Southern Engineers, P.A.
3716 Benson Drive, Raleigh, NC 27609
Phone: (919) 878-1617
License: C-4772
www.southernengineers.com

SMITHFIELD
Garage Right

OPT. PET PALACE
SCALE: 1/8"=1'-0" ON 11x17, 1/4"=1'-0" ON 22x34

Project #: 21-3366-C (Lot 22)
Location: Lot 22, Woodbridge South
Date: 7-31-23
Page: 1 of 1

**FIRST FLOOR PLAN 'FRENCH COUNTRY'**  
SCALE: 1/8"=1'-0" ON 11x17, 1/4"=1'-0" ON 22x34

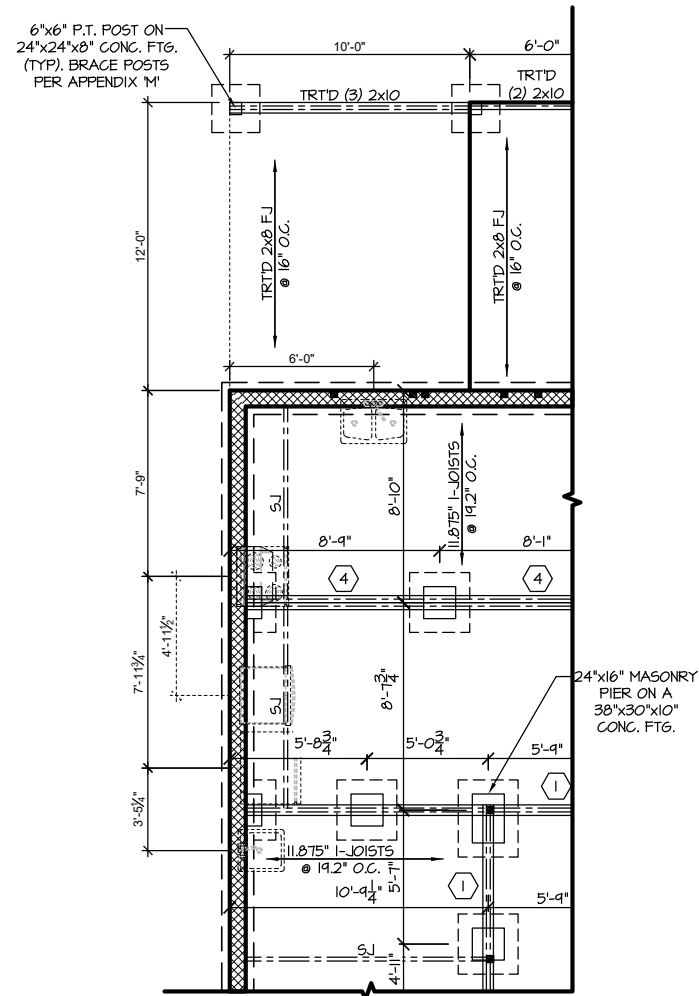
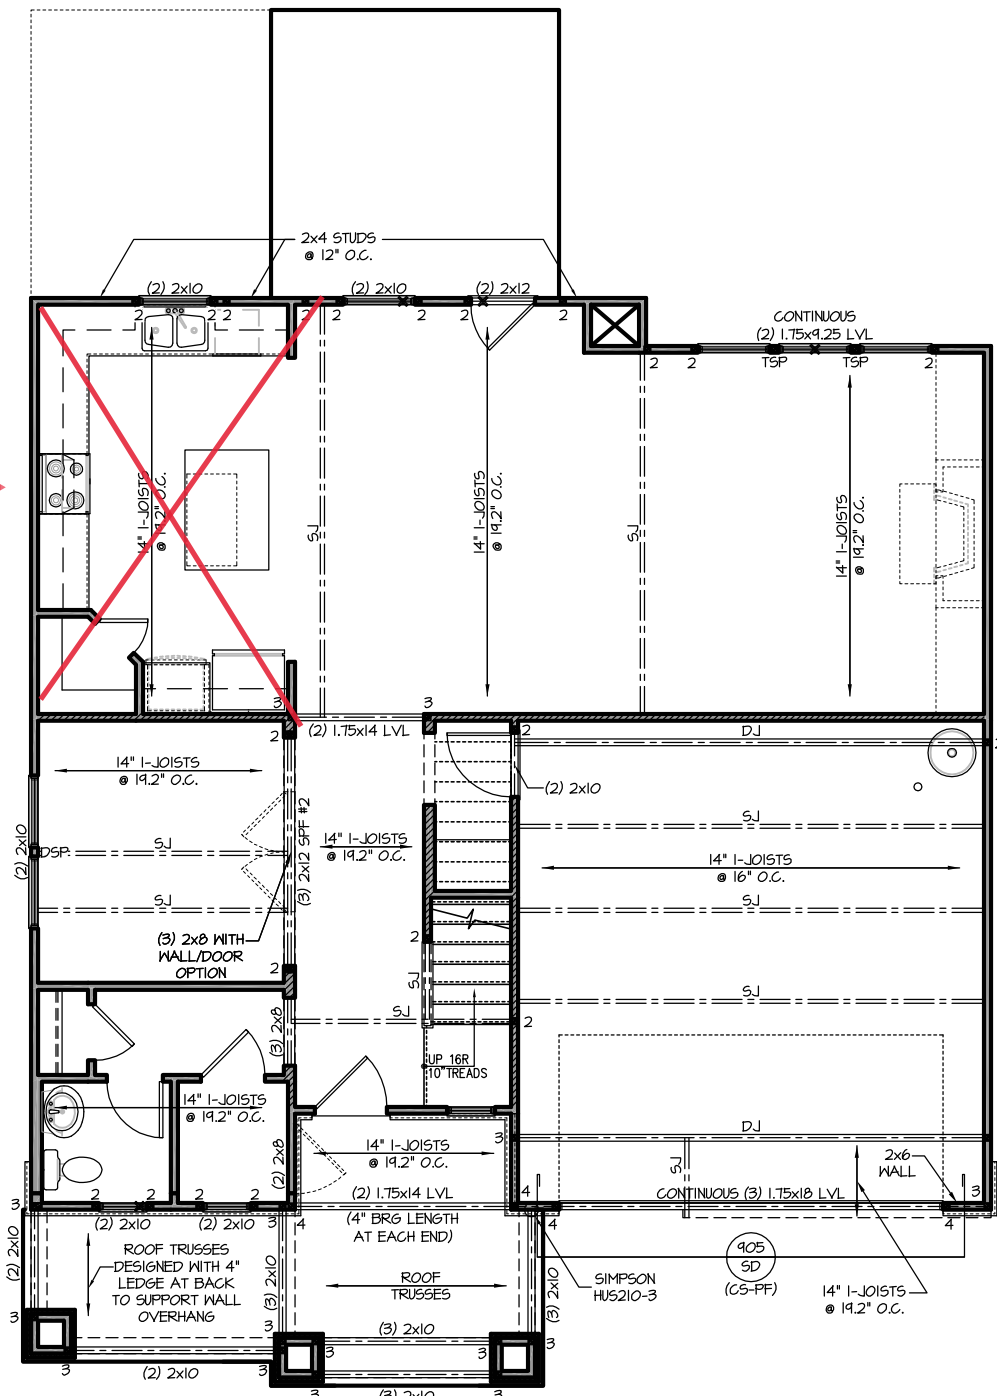
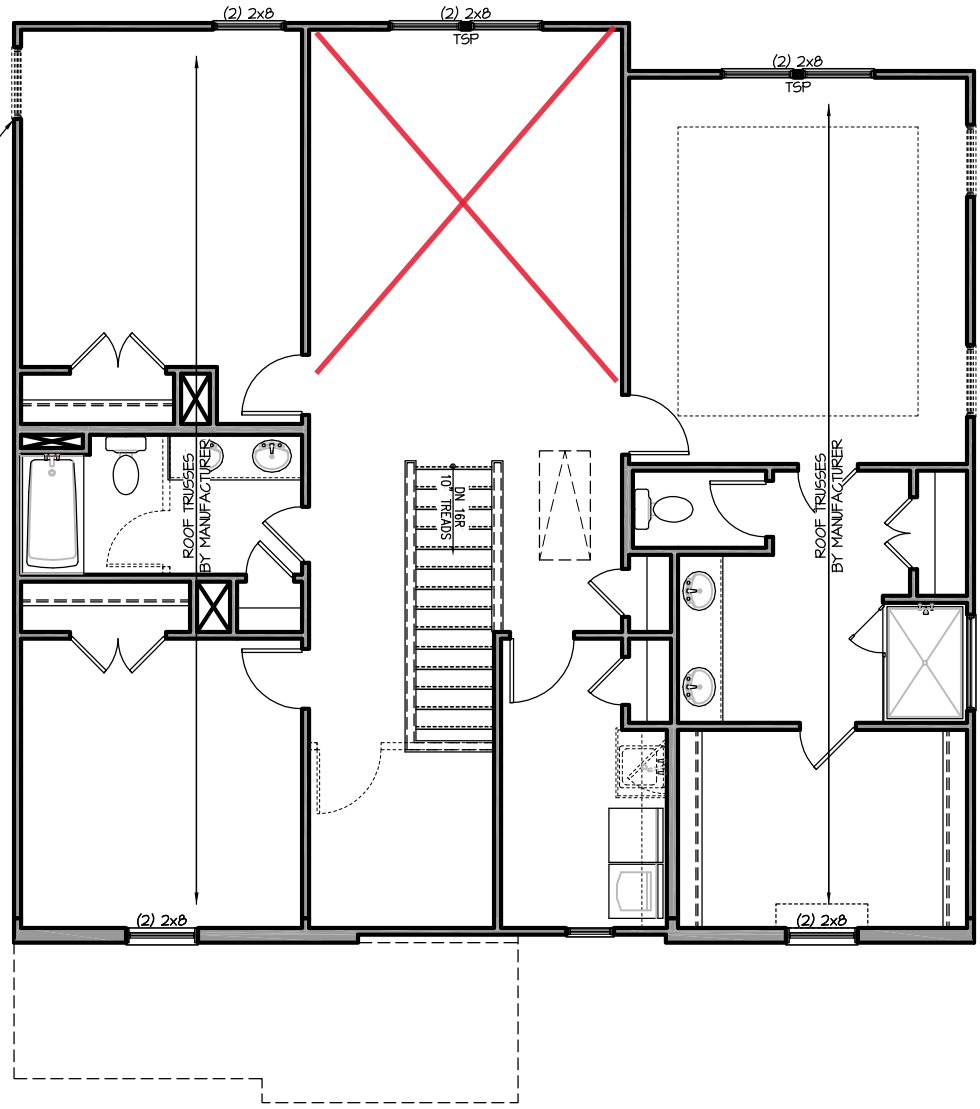
NOTED ISSUE: HEADER WAS SET DIRECTLY BELOW TOP PLATES AND BEAM IS BEARING ON TOP PLATES. SOLUTION: CUT OUT 1'-0" SEGMENT OF TOP PLATES BELOW END OF BEAM. INSTALL 3.5"X3" PLATE OF 1.5E LSL OR 1.9E LVL OR BETTER AT 1'-0" LONG CUT OUT. ATTACH NEW LVL/LSL PLATE TO LVL HEADER ON EACH SIDE OF (3) 1.75X16 LVL BEAM WITH (2) 1/4"x5" WOOD SCREWS. ATTACH LVL/LSL PLATE TO TOP PLATES AT ENDS W/ A SIMPSON LTP6 PLATE.
